Online Comment

Application H22-0599-24
Location Broadgate Barns 694 Broadgate Weston PE12 8JA
Proposal Erection of outbuilding comprising of a gym, home office & associated facilities

Name Greg Watkinson
Address Conservation Officer

Drawing Title:
**Plans, section, Elevations and 3D
images as proposed**
PLANNING APPLICATION ISSUE

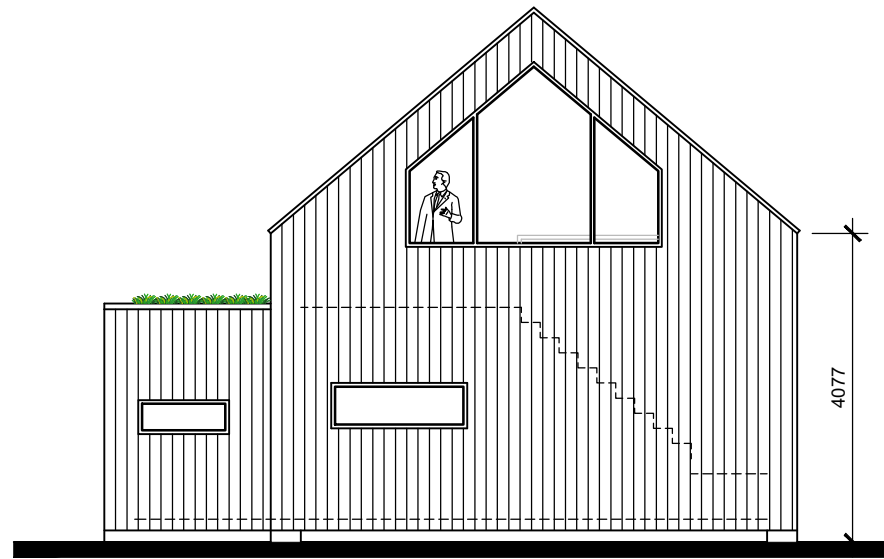
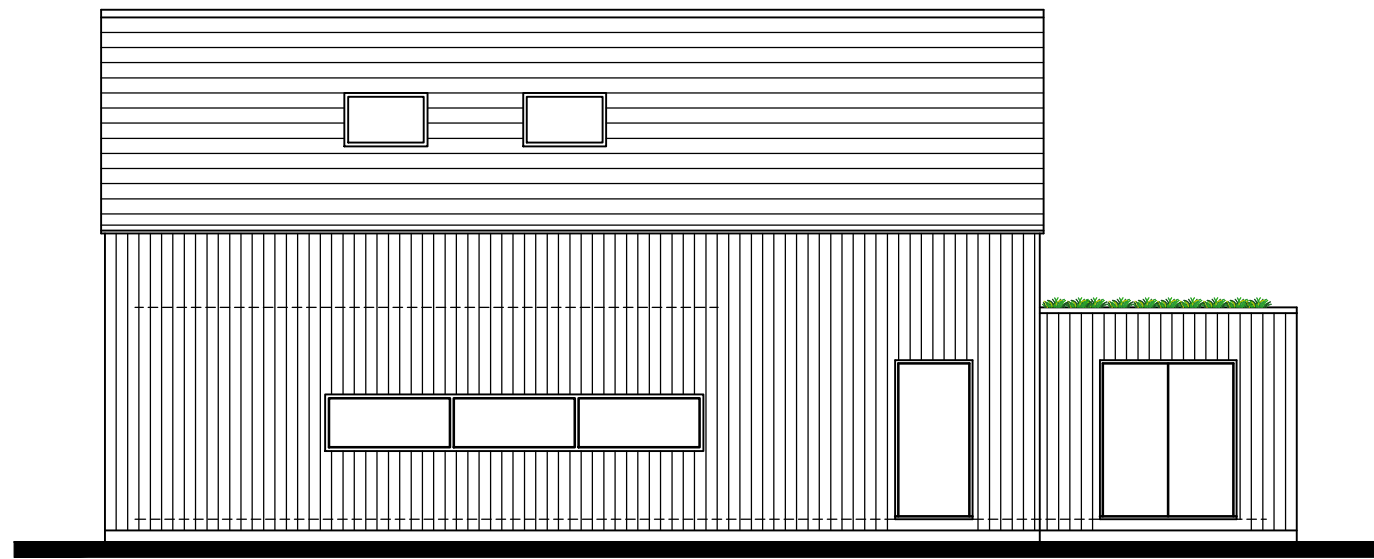
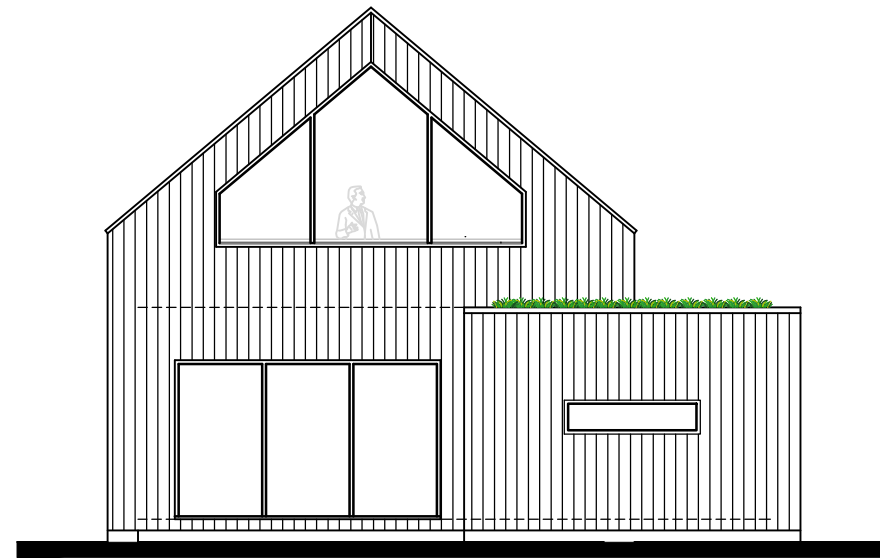
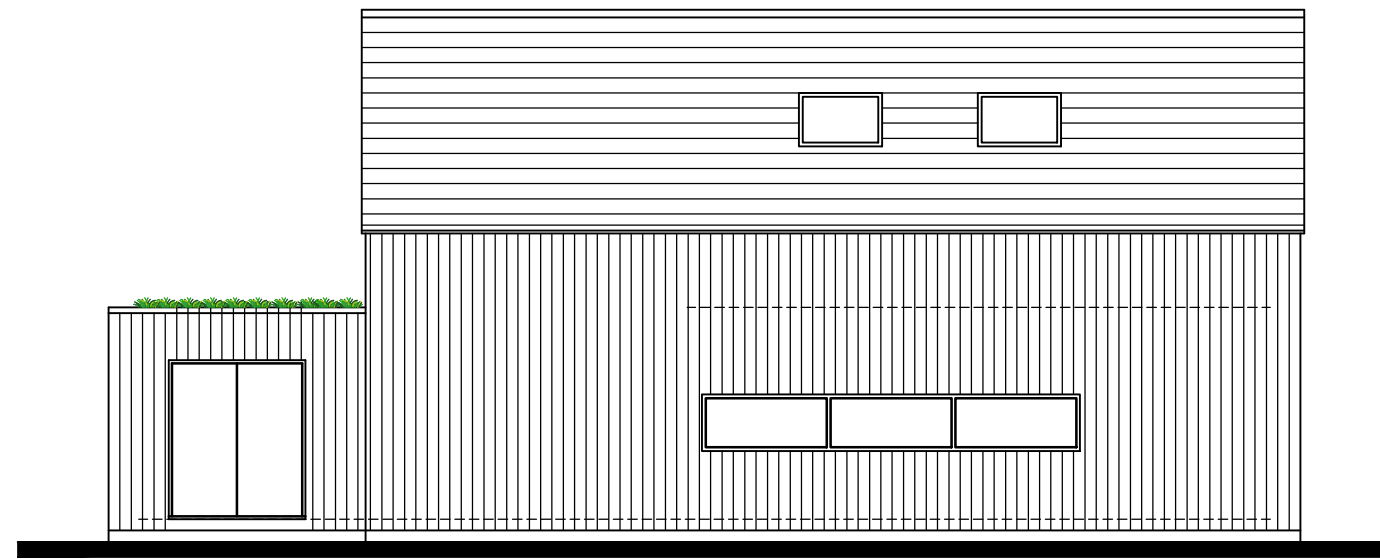
I would, however, suggest that any approval be accompanied by conditions that require the details of the external materials, windows, doors and roof lights to be agreed by the LPA before commencement beyond oversight - this is in recognition of the fact that the site still is within the historic environment, and as such, final details of the materials should be commensurate, and as yet, it appears only vague details of the materials have been provided at this stage.
